From: Charlotte Burrows on behalf of Planning.Responses
Sent: 26 June 2013 09:30
To: Planning Scanning; Amanda Scholes
Subject: FW: Planning Consultation on: M/24/13/
Attachments: Engineers - Supplementary Guidance Notes For Surface Water Drainage Proposals.pdf

Engineers comments in respect to surface water drainage:

Site Address: White Horses 9 Main Drive Middleton on Sea PO22 7TN

Description of Works: Demolish sub standard bungalow and erect 2 No. semi detached houses.

CLIENT:	Mr and Mrs Pendleton - 44 Southdean Drive Middleton on Sea	DESCRIPTION:	Site Block Plan - Drainage and Installation Plan
PROJECT:	Proposed Semi-detached 3 Bedroom Chalet Dwellings with Parking	SCALE:	1:500
DATE:	April 2013	REVISION:	DRAWING No: 13195/ 2

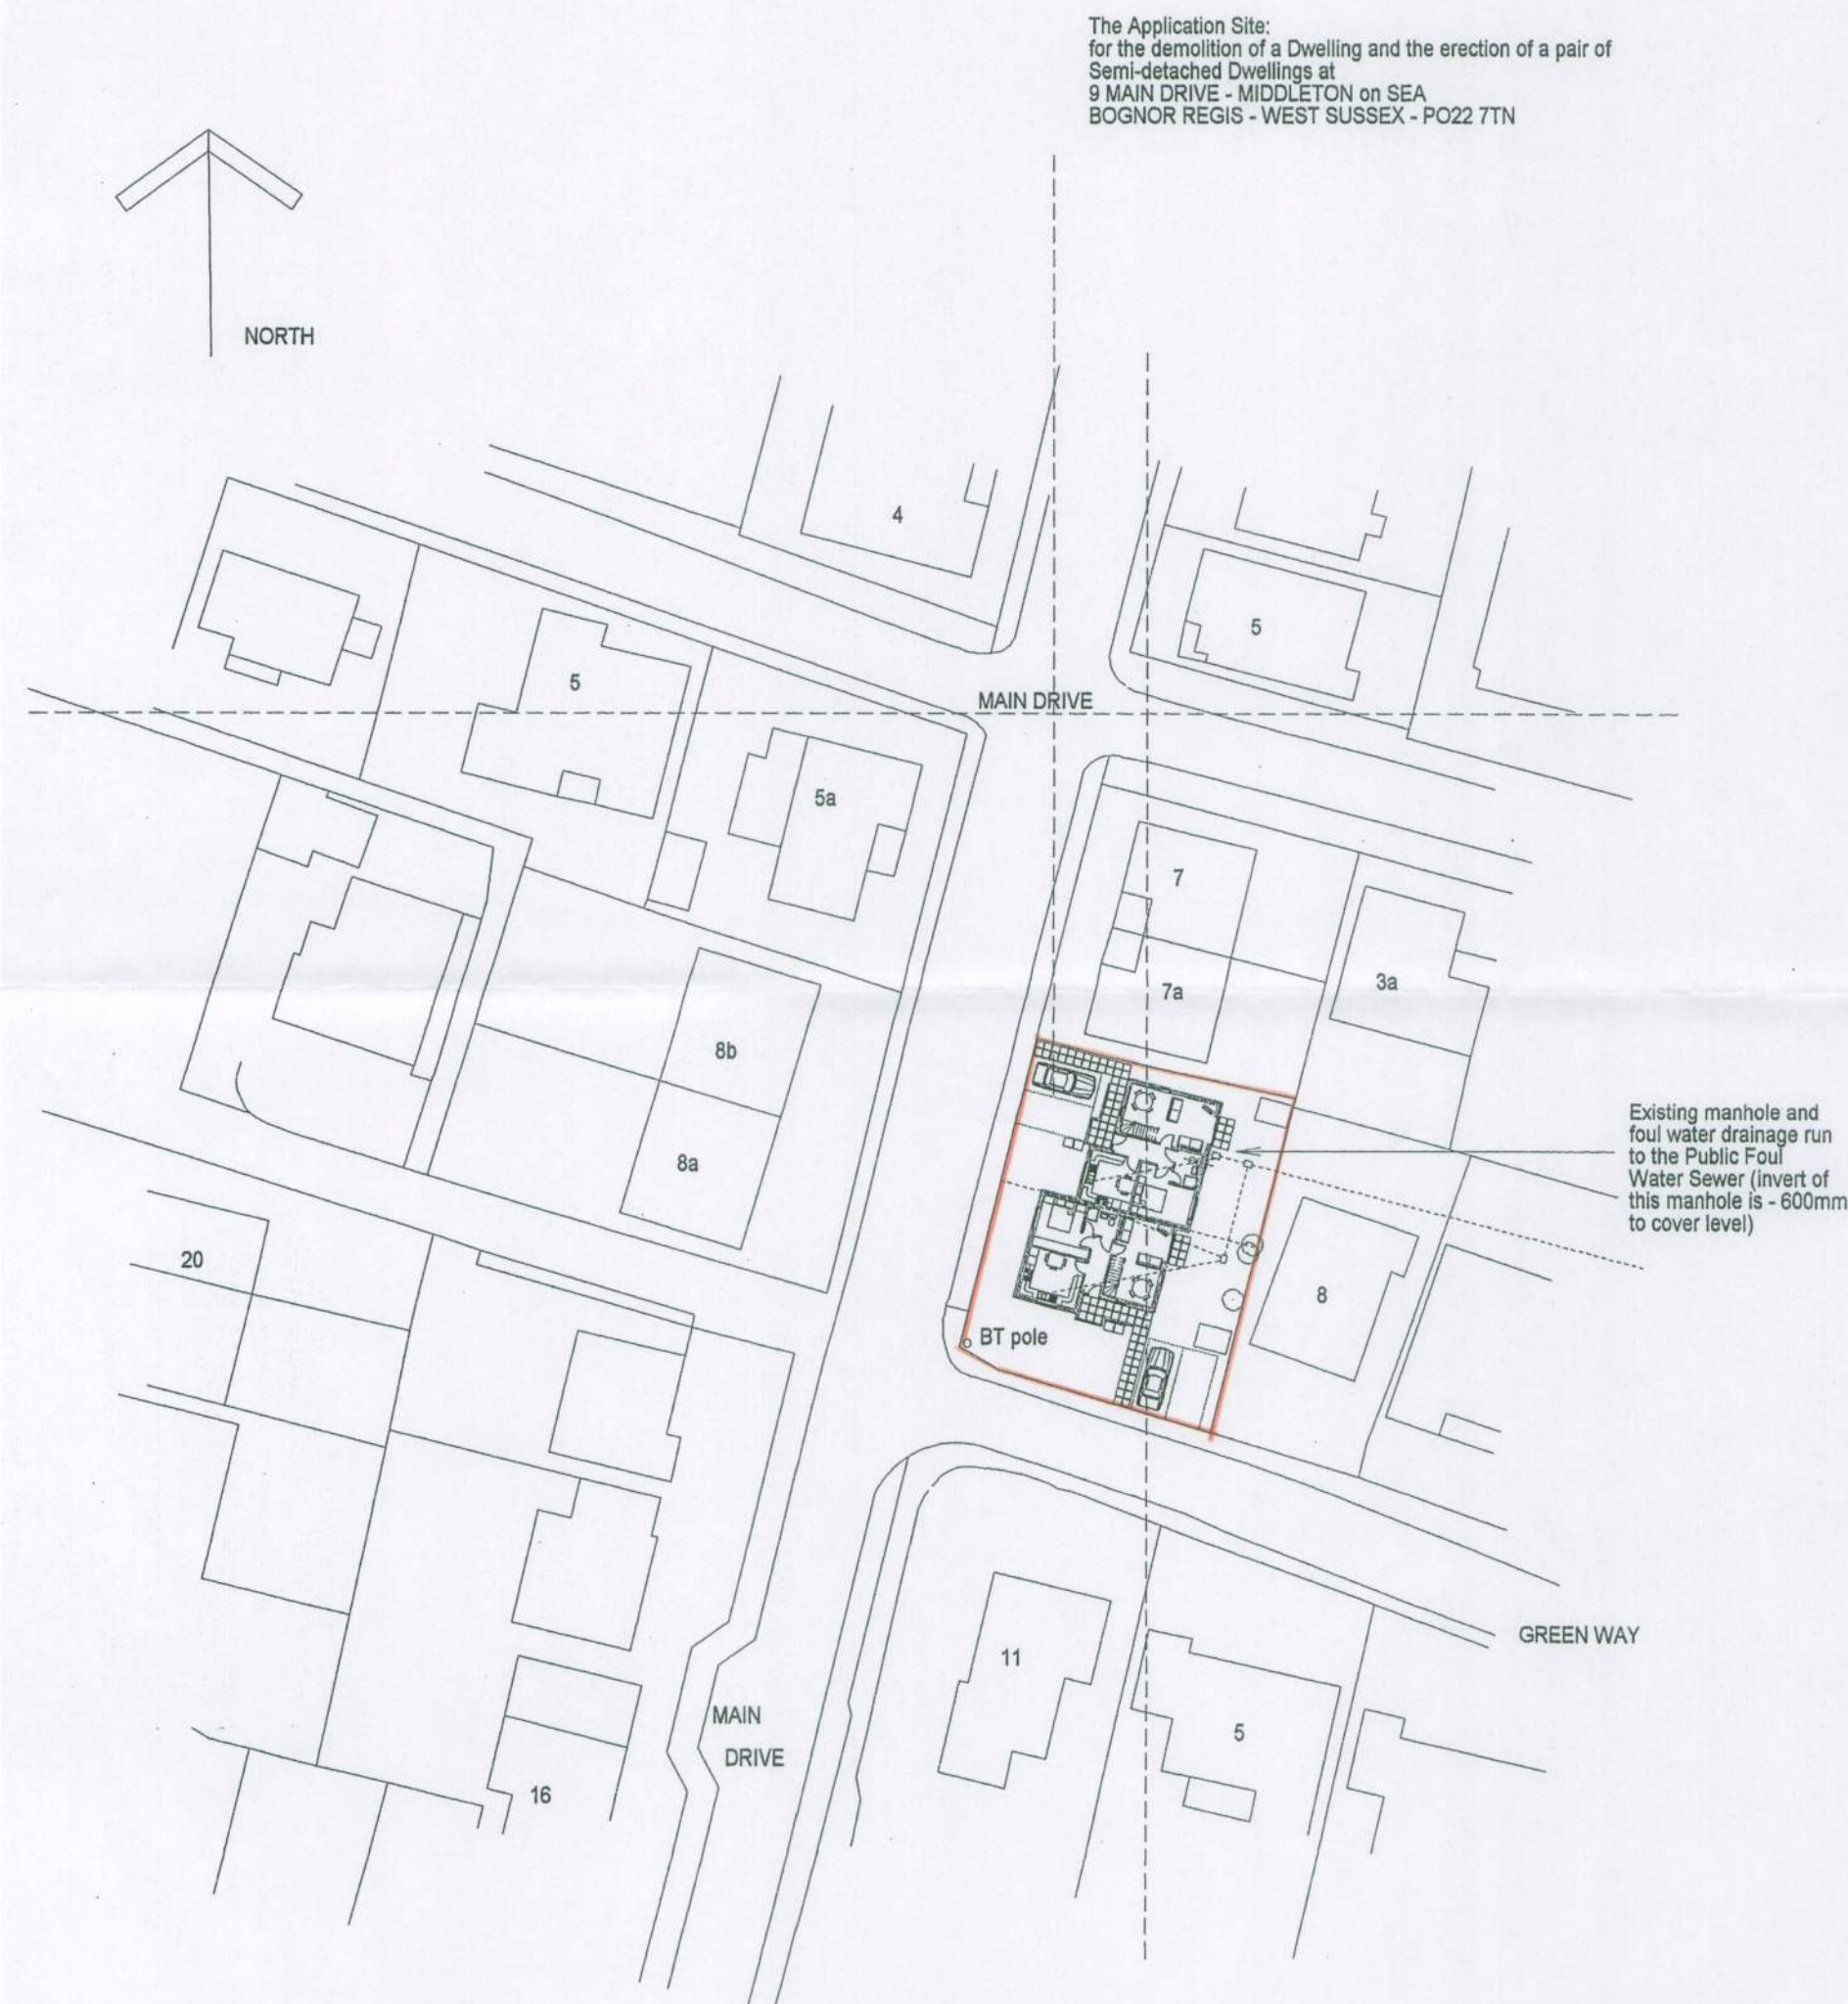
A SuDS system (Sustainable Urban Drainage System) must be investigated for surface water disposal, ie. soakage structures. Soakaways have been specified on the applicants proposals.

Infiltration rates for soakage structures are to be based on percolation tests undertaken in the winter period and at the location and depth of the proposed structures. The percolation tests and design must be carried out in accordance with BRE 365, CIRIA R156 or a similar approved method and cater for the 1 in 10 year storm between the invert of the entry pipe to the soakaway, and the base of the structure. It must also have provision to ensure that there is capacity in the system to contain below ground level the 1 in 100 year event plus 30% on stored volumes, as an allowance for climate change. Adequate freeboard must be provided between the base of the soakaway structure and the highest recorded annual groundwater level identified in that location.

Any SuDS or soakaway design must include adequate groundwater monitoring data to determine the highest winter groundwater table in support of the design. The applicant is advised to discuss the extent of groundwater monitoring with the Council's Engineers. Supplementary guidance notes are also enclosed for information.

Please apply standard conditions ENGD2A.
